DOC21/1042313

24 November 2021

**Upper South Creek Advanced Water Recycling Centre (AWRC) (SSI 8609189)
EPA advice on Environmental Impact Statement (EIS)**

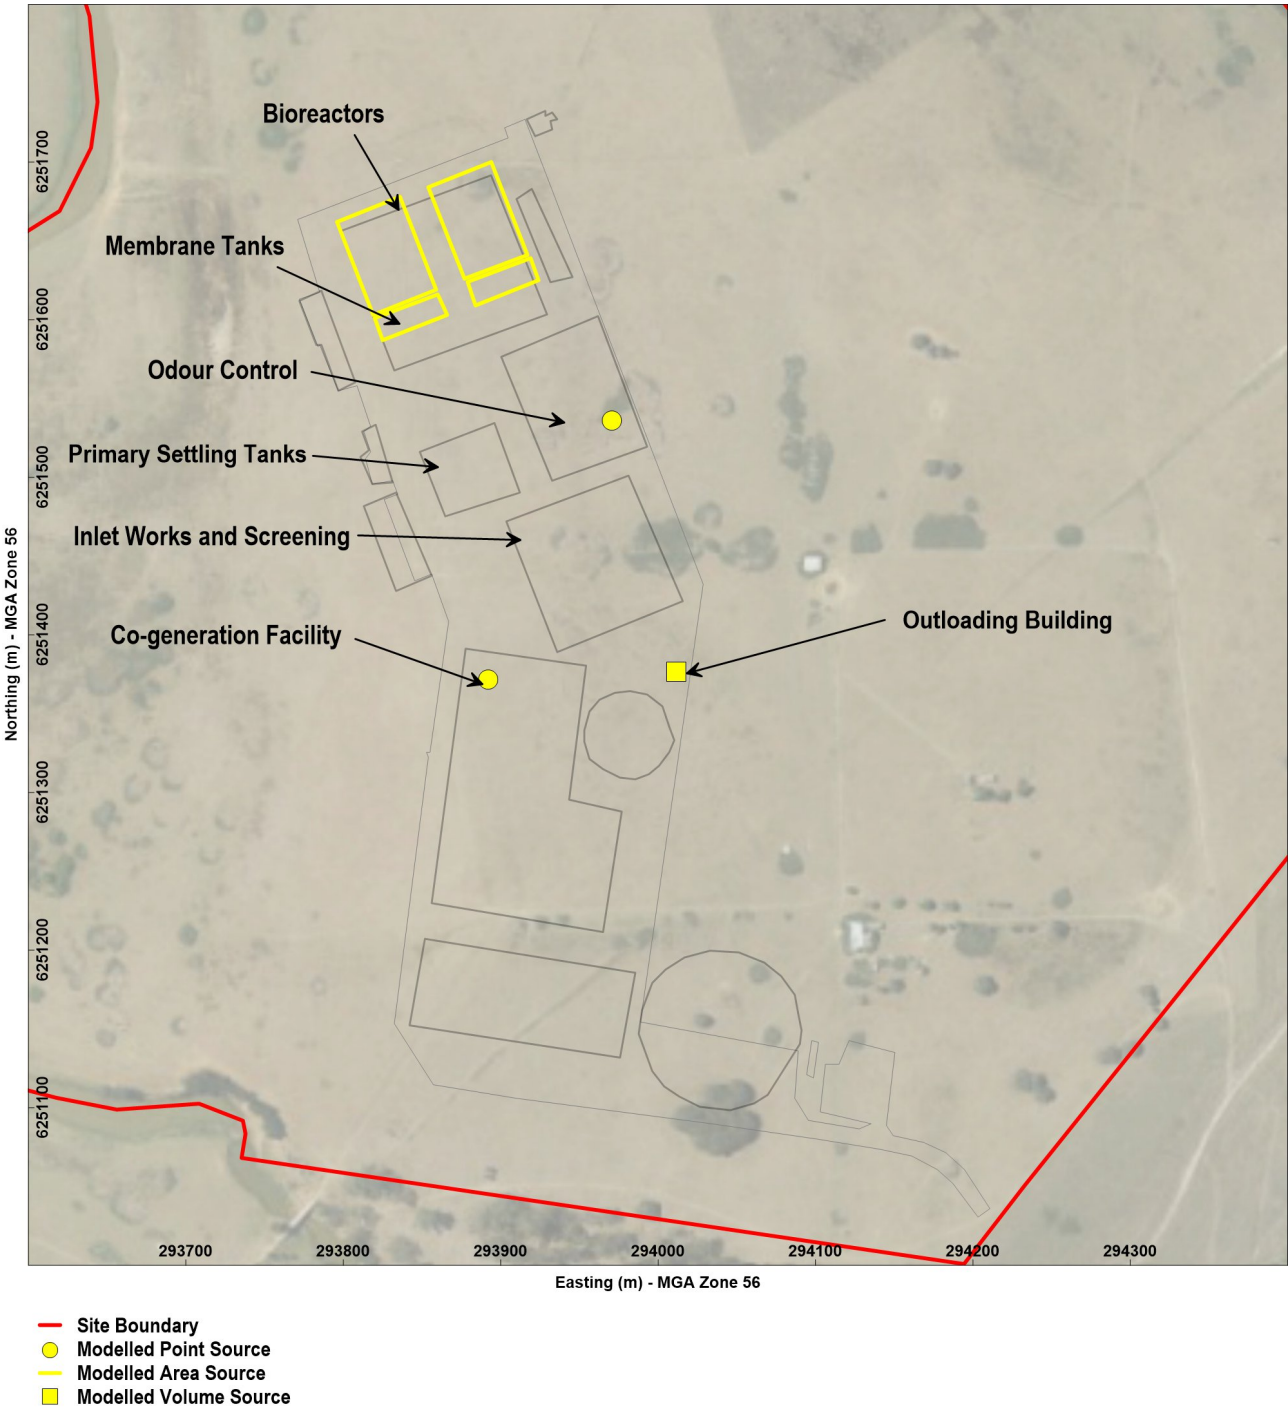
The biosolids loadout building has been modelled as a volume source, using a flow rate of 10 m³/s. The method used to calculate this emission rate has not been detailed. Furthermore, biosolids loadout emissions have only been modelled for the hours between 7 am and 3 pm. There is no justification for why this time period is appropriate, and how odours will be controlled outside of this period.

The EPA recommends the AQIA be updated to include robust justification for the emission rates adopted in the dispersion modelling assessment.

Figure 10 Predicted odour levels at the 99th percentile due to the AWRC (50 ML/d)

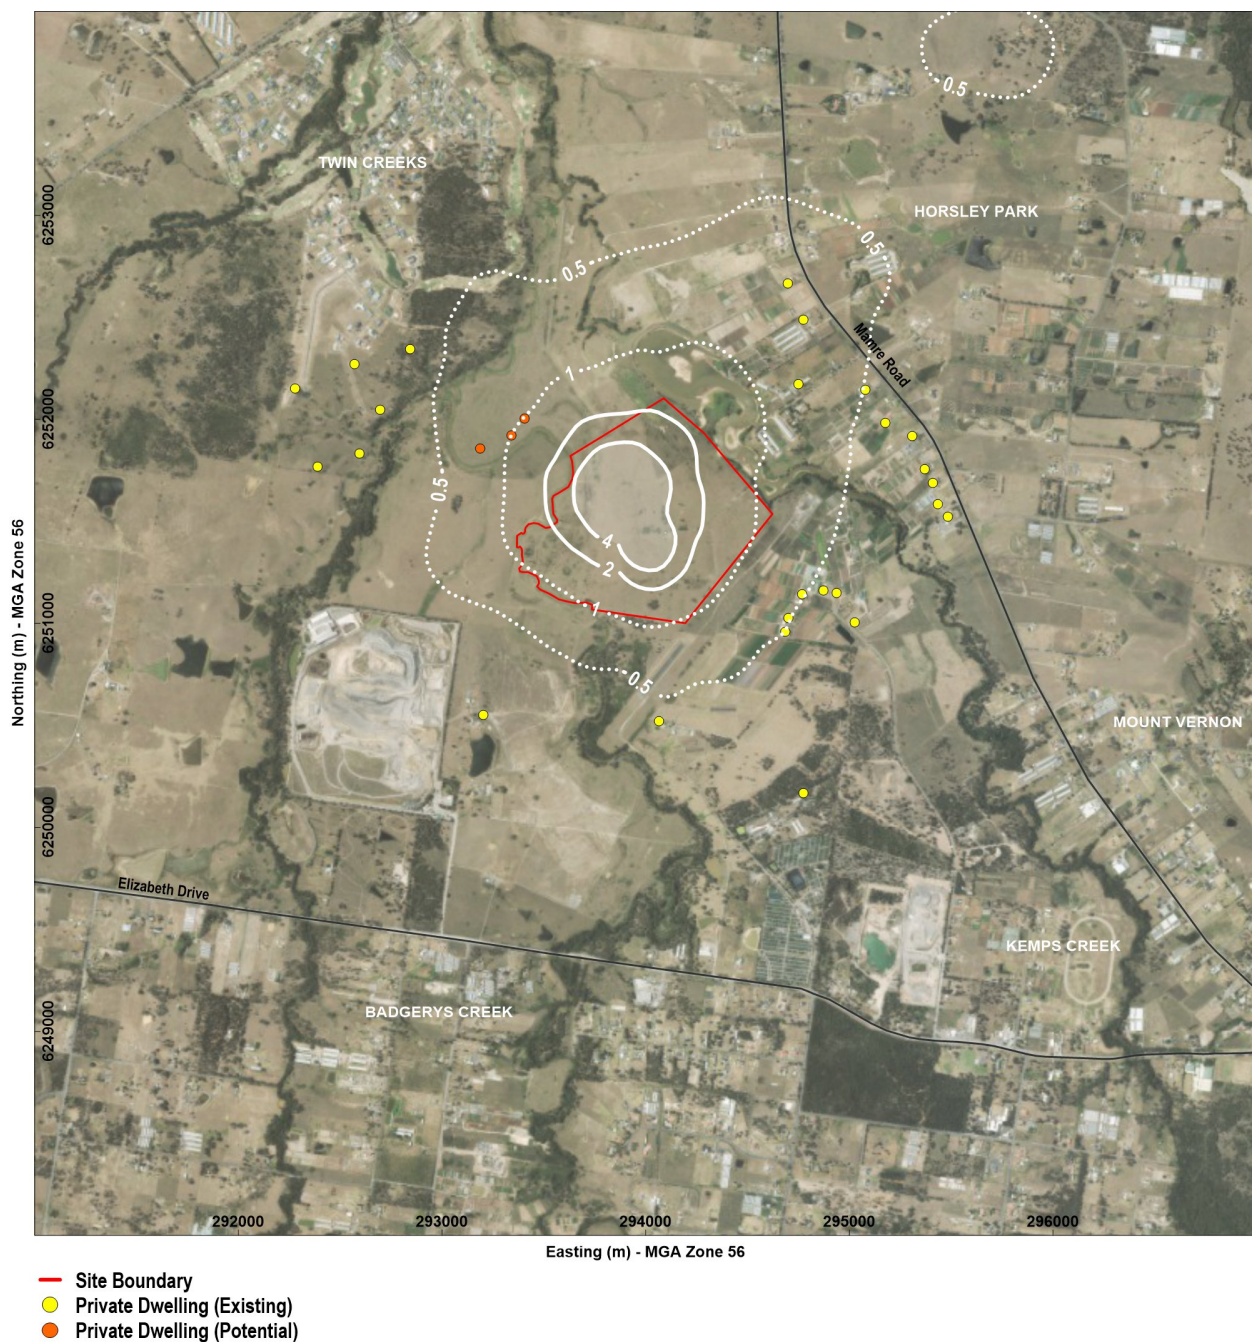
The results of the dispersion modelling are presented as contour maps. Figure 10 in the AQIA shows the predicted incremental odour concentrations (99th percentile) for the 50 ML (Stage 1) scenario. The contours indicate compliance with the EPA's¹ impact assessment criterion (IAC) of 2OU (for urban areas) at nearby sensitive receptors (both existing and future). Figure D2 in the AQIA presents the results for the 100 ML modelling scenario. Only marginal compliance with the EPA's 2OU criterion is predicted at future likely sensitive receptors with impacts between 1 and 2 odour units being predicted.

Whilst the modelling presents marginal compliance with the EPA's IAC, there is some uncertainty regarding the adopted emission rates used in the modelling.

The Sydney Water odour emissions database has been used to develop estimates of maximum emissions from the proposed AWRC. Emission test data from other treatment plants has been relied upon to develop the emissions inventory. However, it has not been adequately demonstrated that the adopted emissions are appropriate for the proposed plant design and scale of the operations. Furthermore, it has not been shown that the adopted emission rates represent reasonable worst case.
